Reference: 21.185r03v01

3 June 2022

Re: St Aloysius – Rozelle Campus
Response to Request for Information

| Project No. 21.185 | Drawing Phase DA | Drawing No. TX.01 | Rev. D |

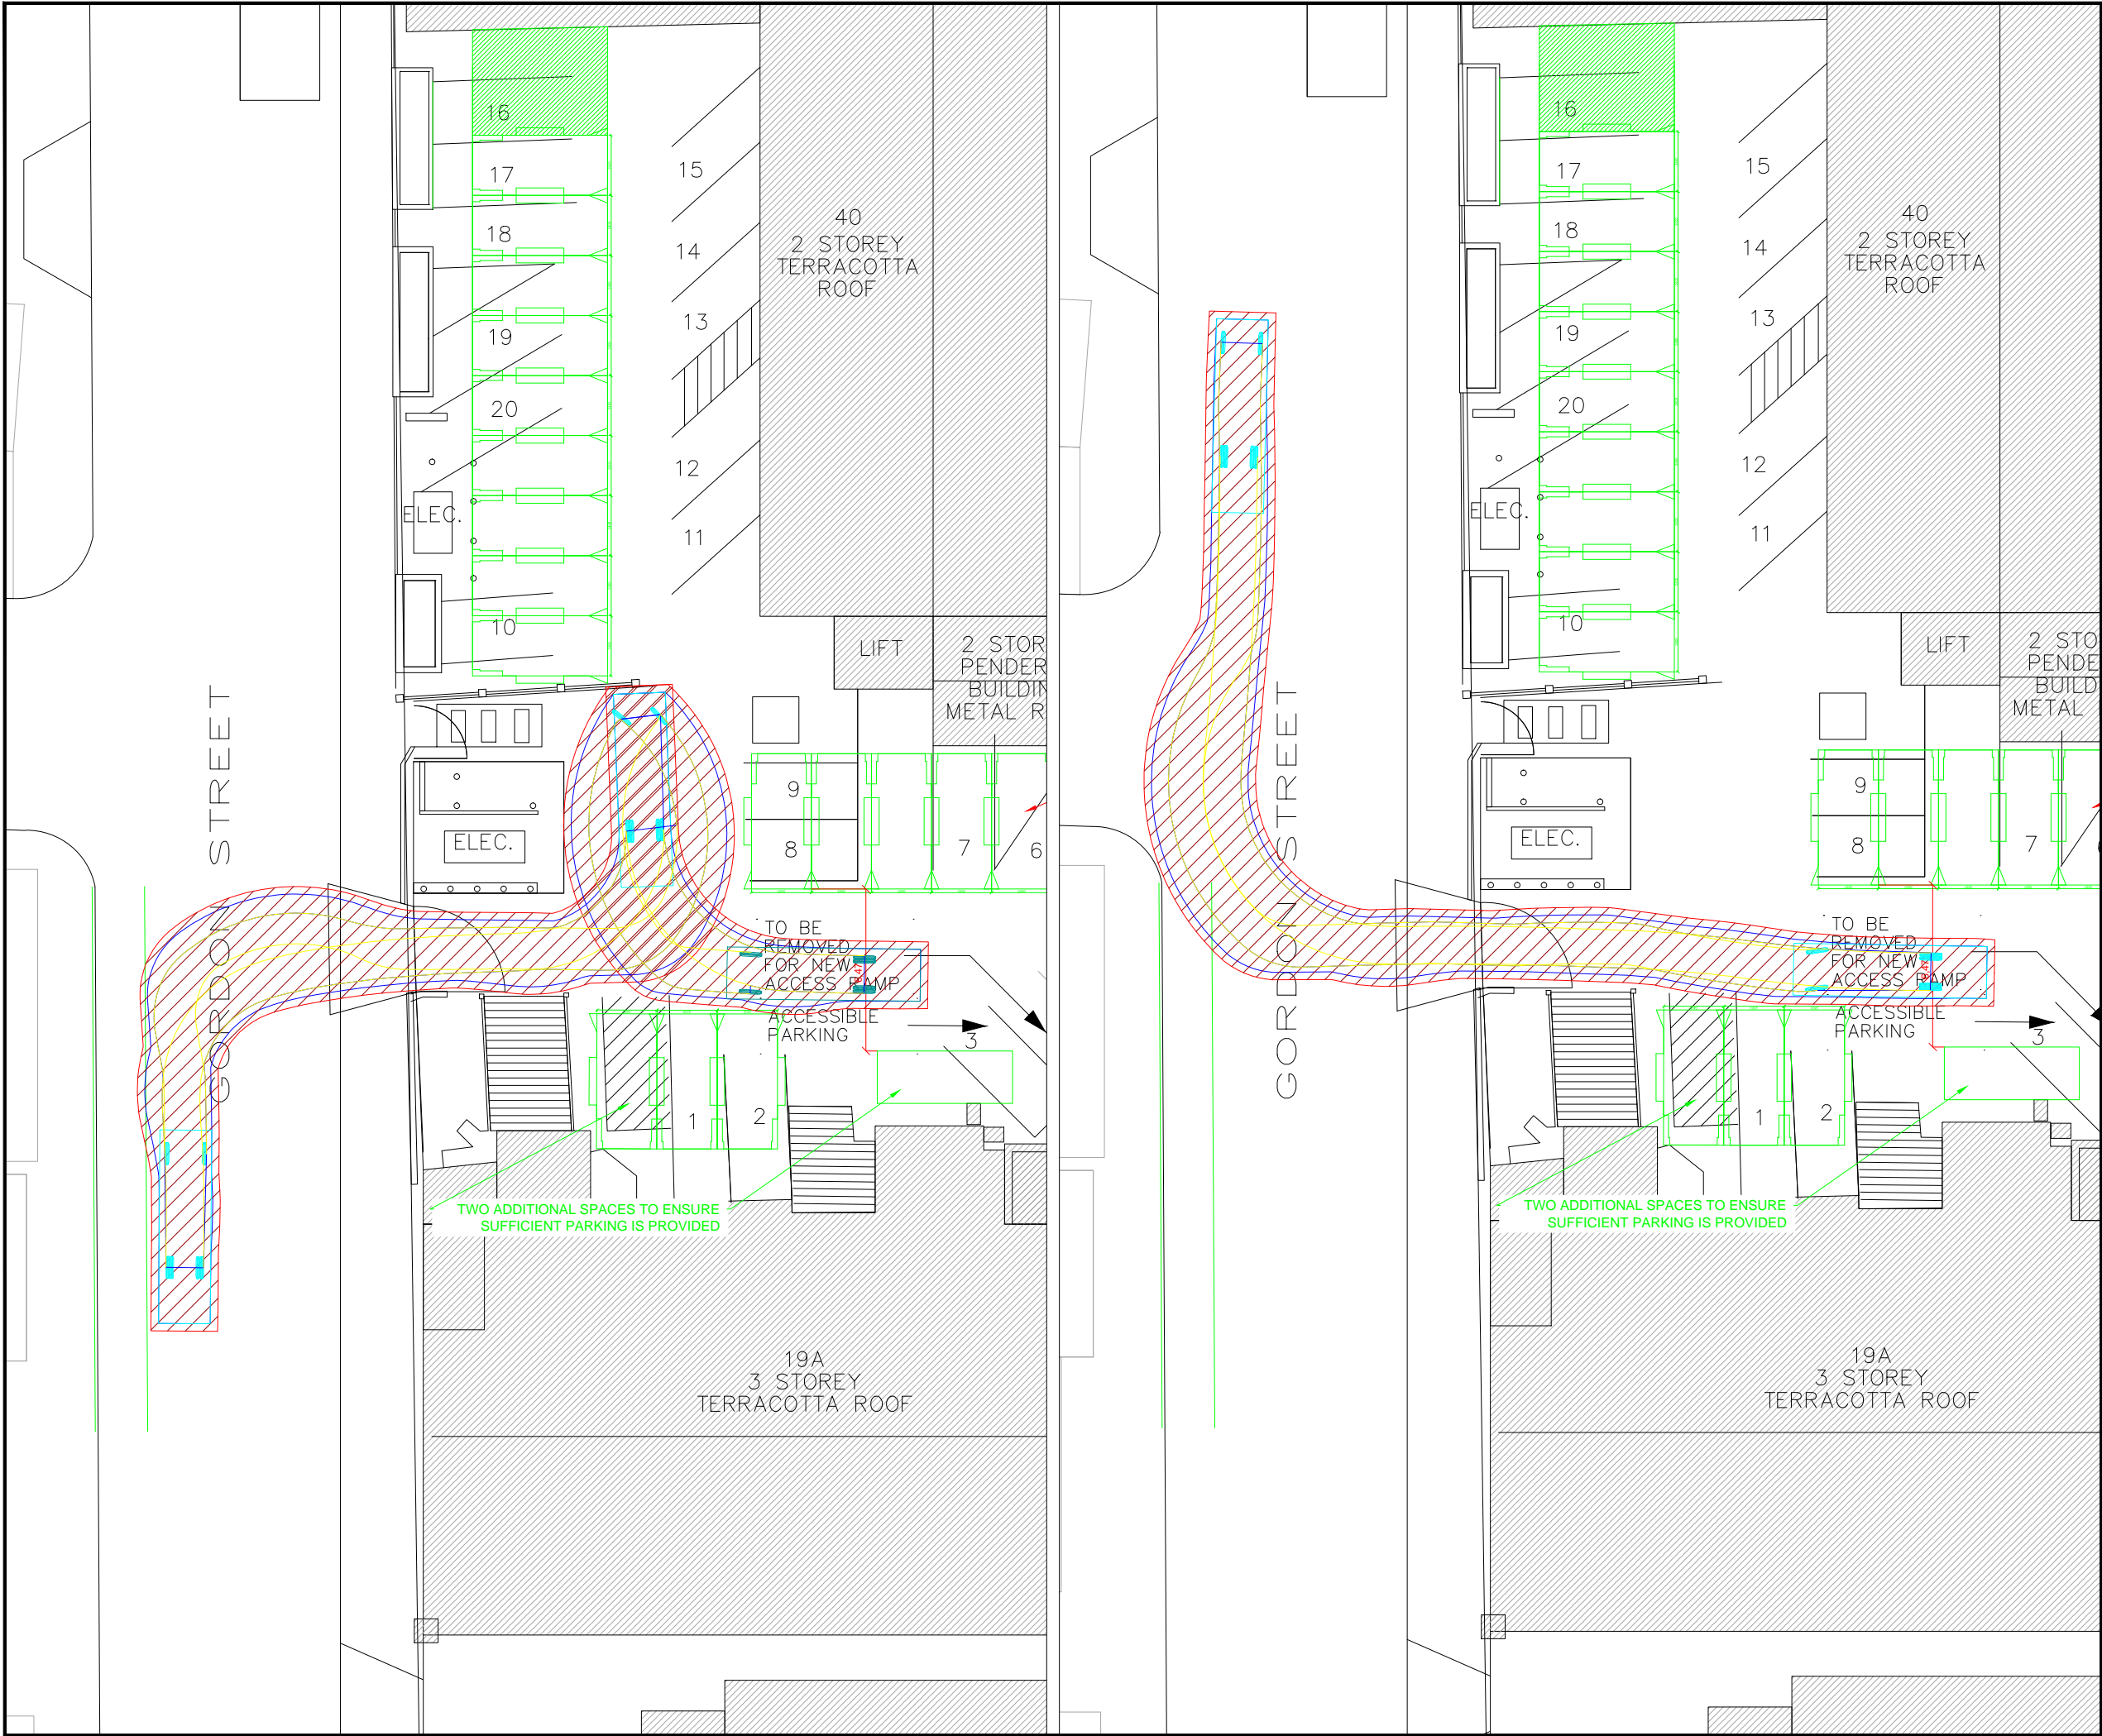
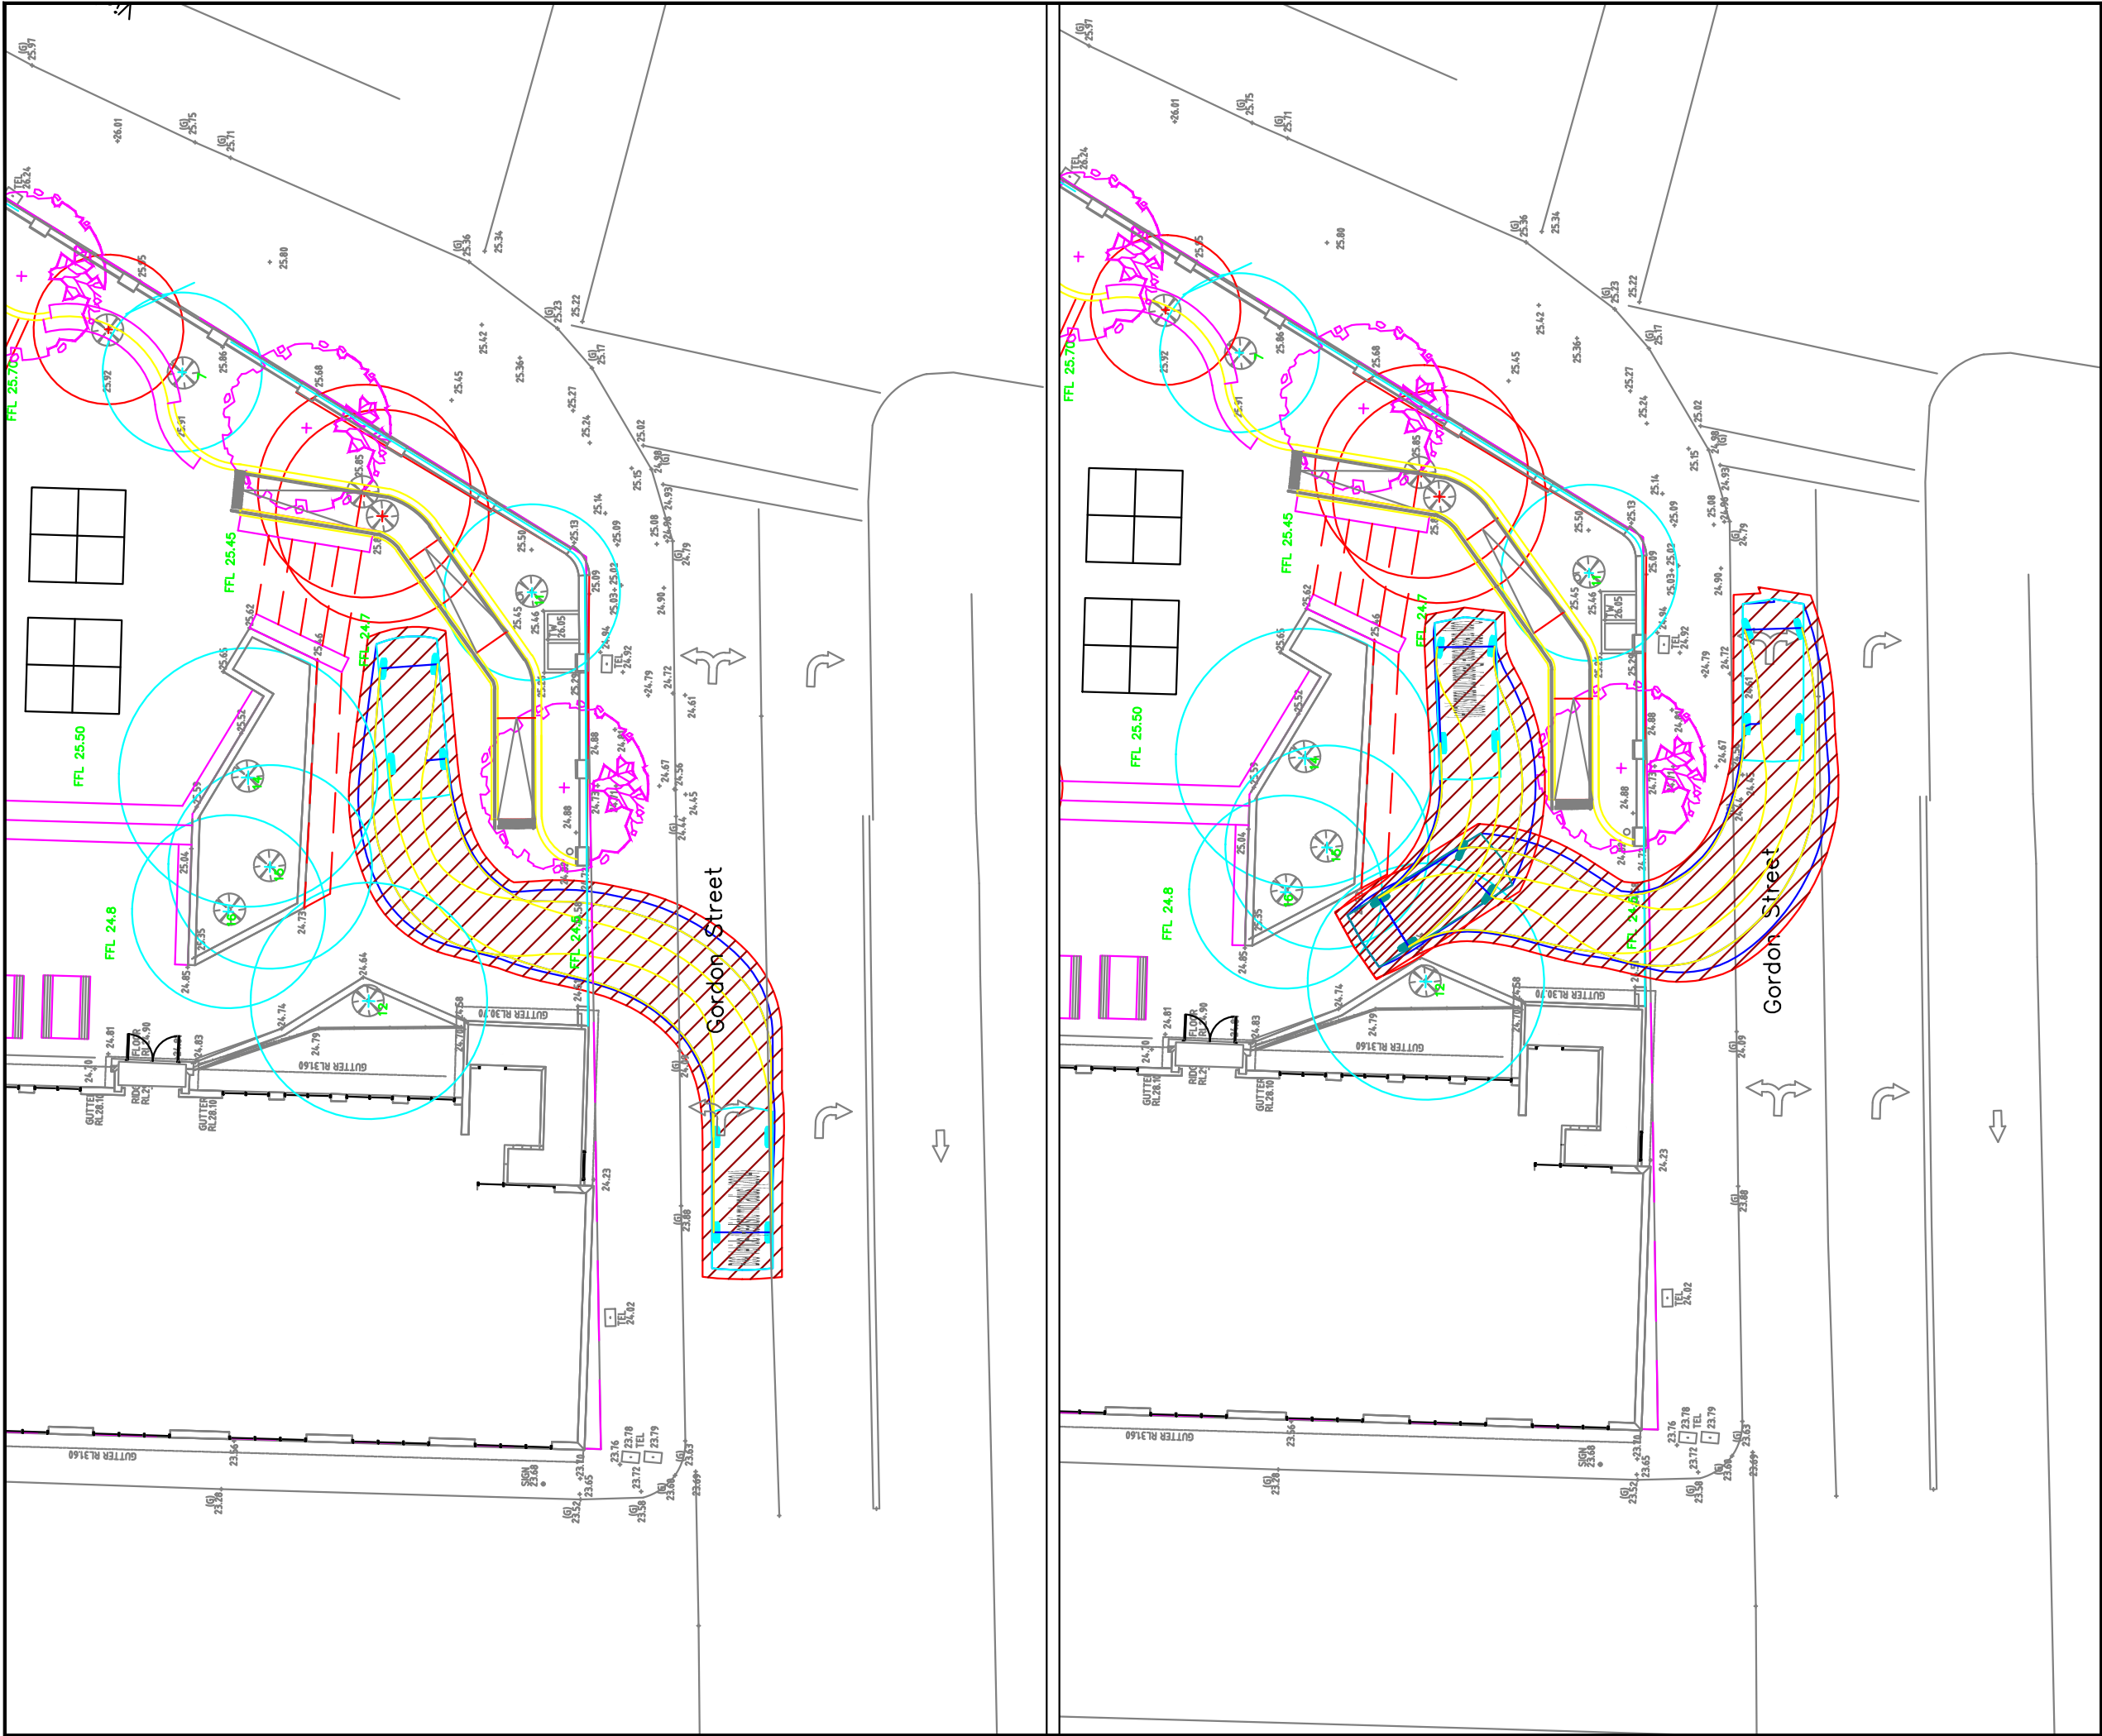
- i) As shown in Figure 1 below, the swept paths show that the manoeuvre is very tight, and the gate encroaches within the 300mm clearance bands either side of the vehicle. Further investigation should be undertaken to explore whether there is scope to widen the entry gates and driveway.

- ii) As shown in Figure 2 below, the swept path also details that the shuttle bus will impact a bollard protecting the electricity substation and drops off the edge of the kerb shown circled in red (Figure 3). Further investigation should be undertaken to explore whether there is scope to set the kerb back and to relocate the bollard to allow for better manoeuvrability of the shuttle bus.

- i) The updated swept path in the latest TAIA report (Ref: 21.185r01v07 dated 3 June 2022) shows that there is sufficient width of the driveway to accommodate both the body of the vehicle and the 300mm clearance on either side of the vehicle (red line) which meets the requirements of AS 2890.2 (2018).
- ii) The swept path analysis has been amended and is presented in the latest TAIA. This updated swept path analysis shows that the shuttle bus can manoeuvre clear of the bollards.
